# Consultant Advice

From:	Kevin Boyle	Date:	31 Mar. 15	File No:	S25186\209\FE\21\ca150329s0002	Pages:	2
Project:	University of Sydney - G02 Jane Foss Russell Building					No:	FE001[1.0]
	Attention	Company	Email				
To:	Alice Dodwell	Savills Project Management	adodwell@savills.com.au

## Fire Engineering - Support for Development Application

The purpose of this CAN is to confirm that Norman Disney & Young (NDY) have undertaken a preliminary review of the proposed works on Levels 3-4 & 6-7 of the Jan Foss Russell building and the associated drawings, to determine if compliance with the base building Fire Engineering Report (FER) is achievable.

drawing
LEVEL 04
EXISTING PLAN

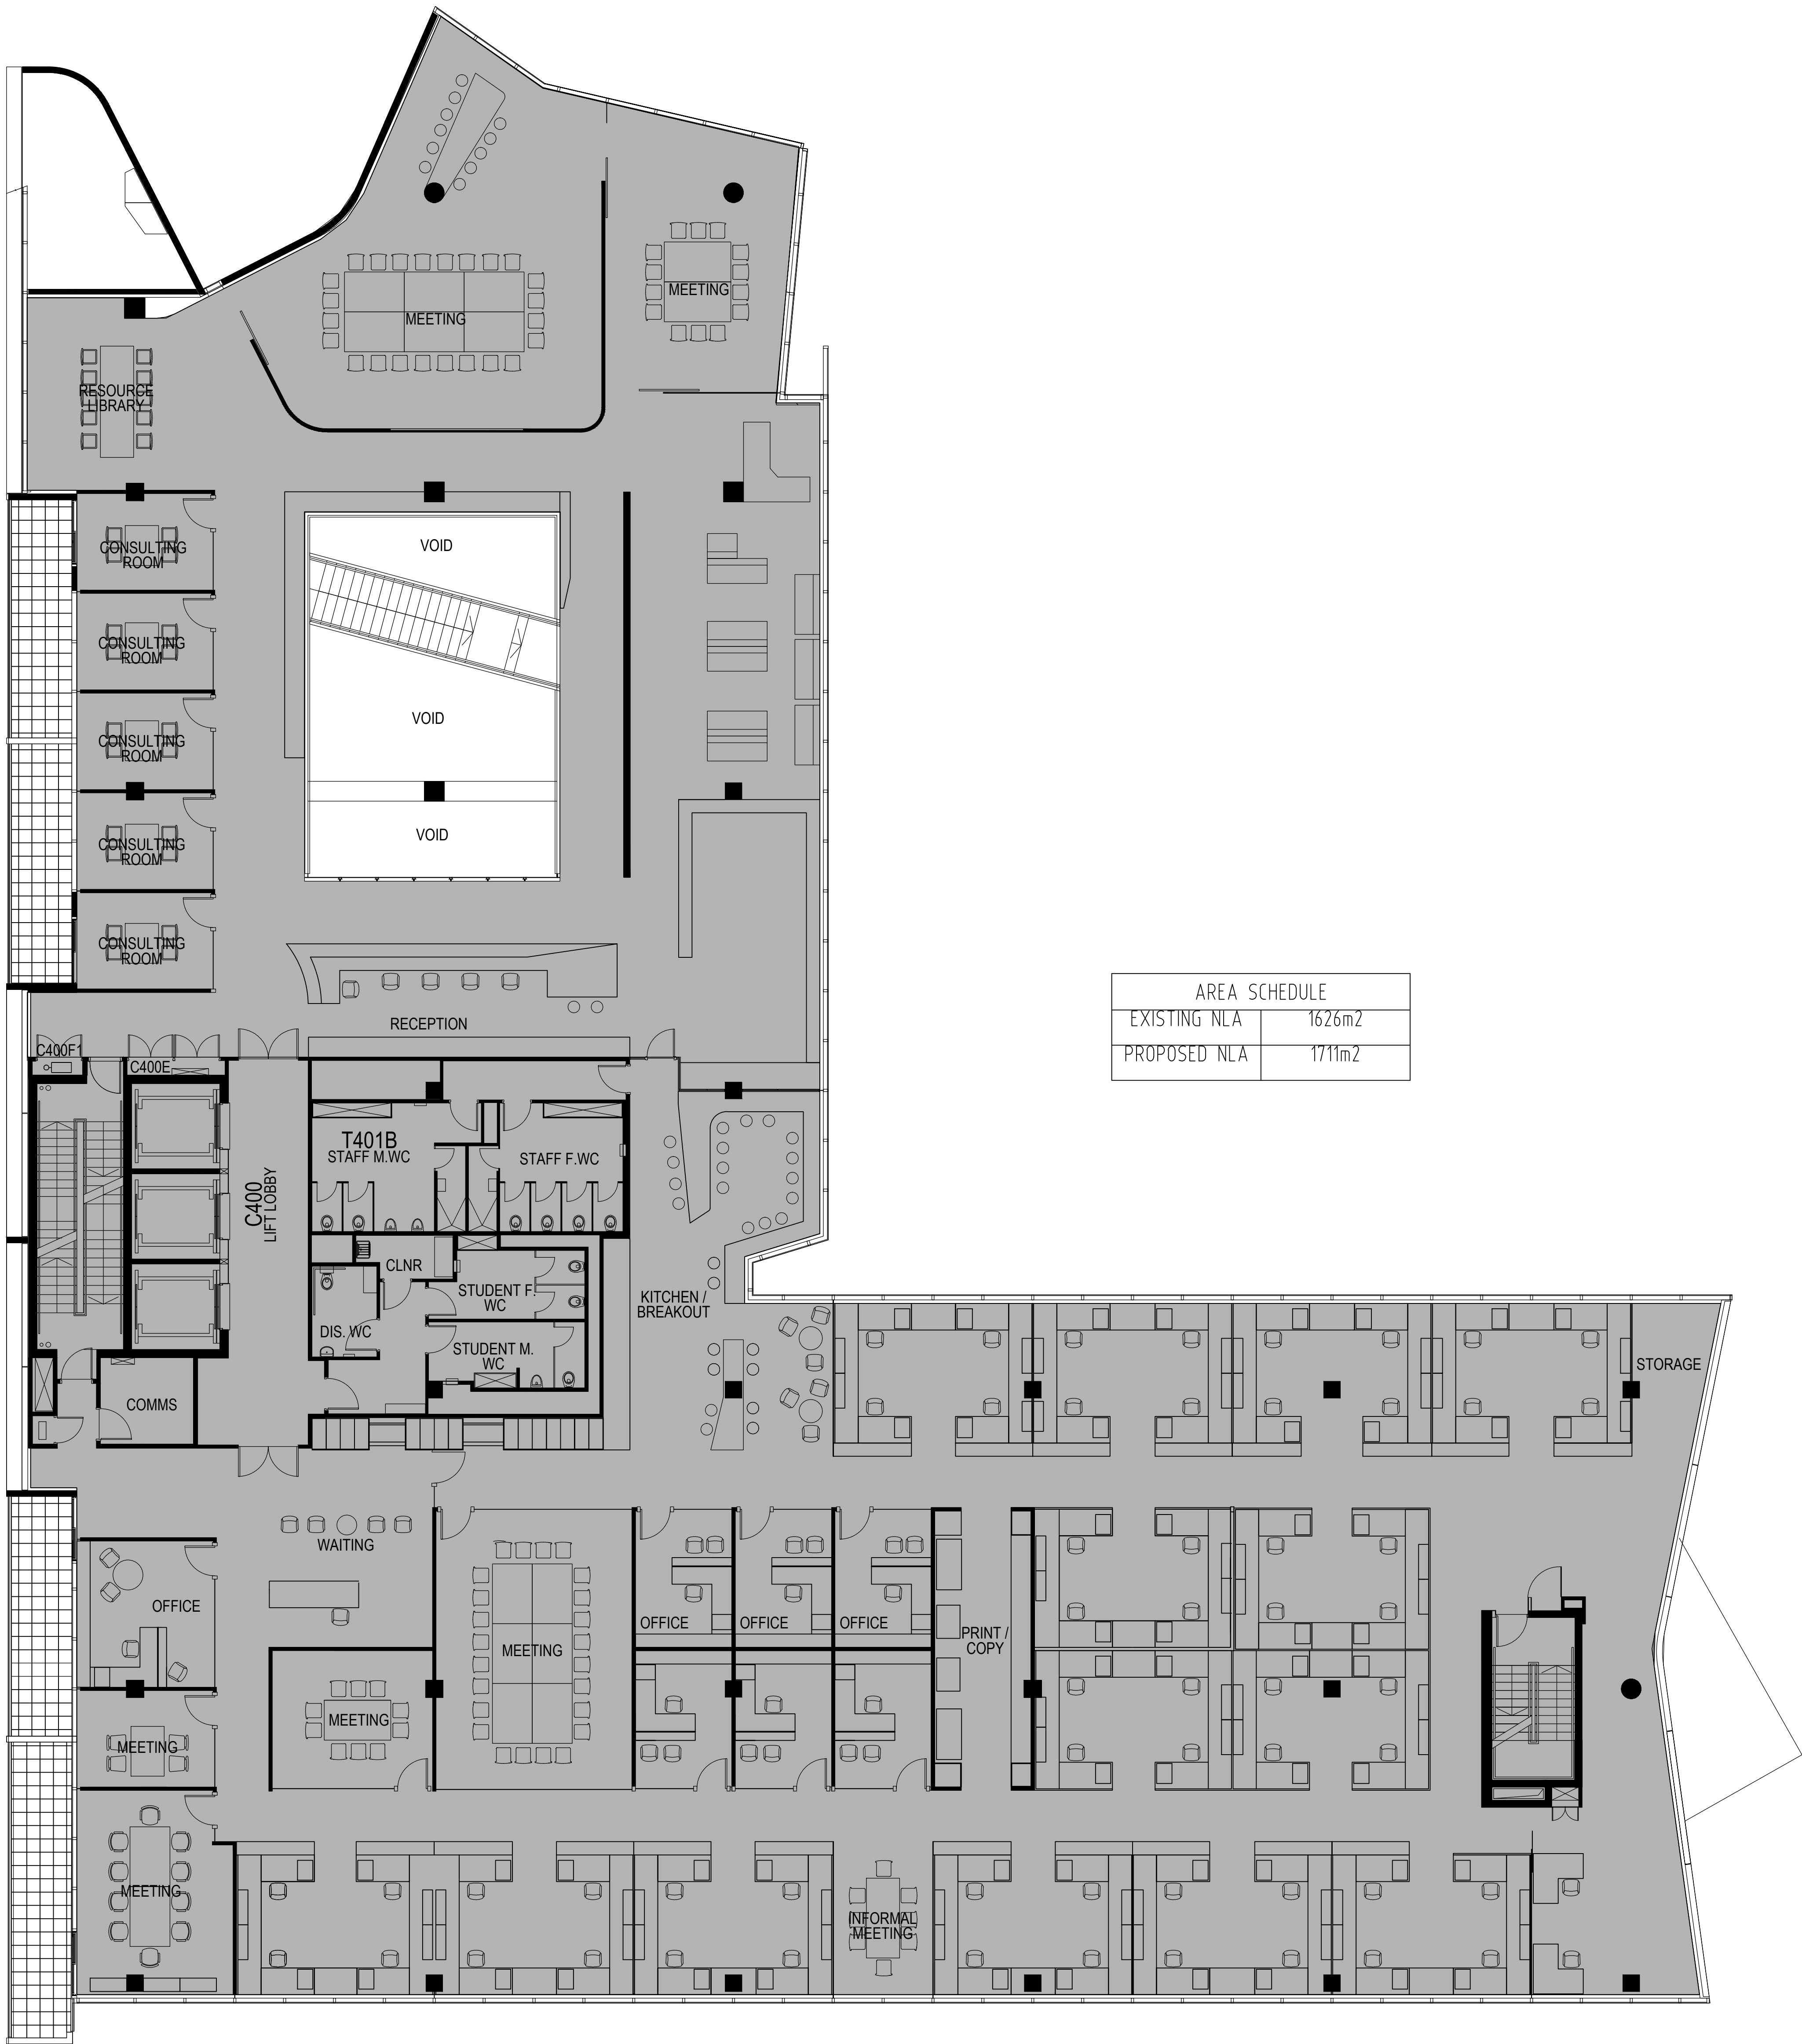
- The floor void between Level 3 & 4 is currently an open egress staircase and shall be in filled to comply with the BCA under specification C1.1 Table 3 achieving an FRL 120/120/120. Although an egress route is omitted there are sufficient exits on the floor to allow occupant to safely evacuate the building.
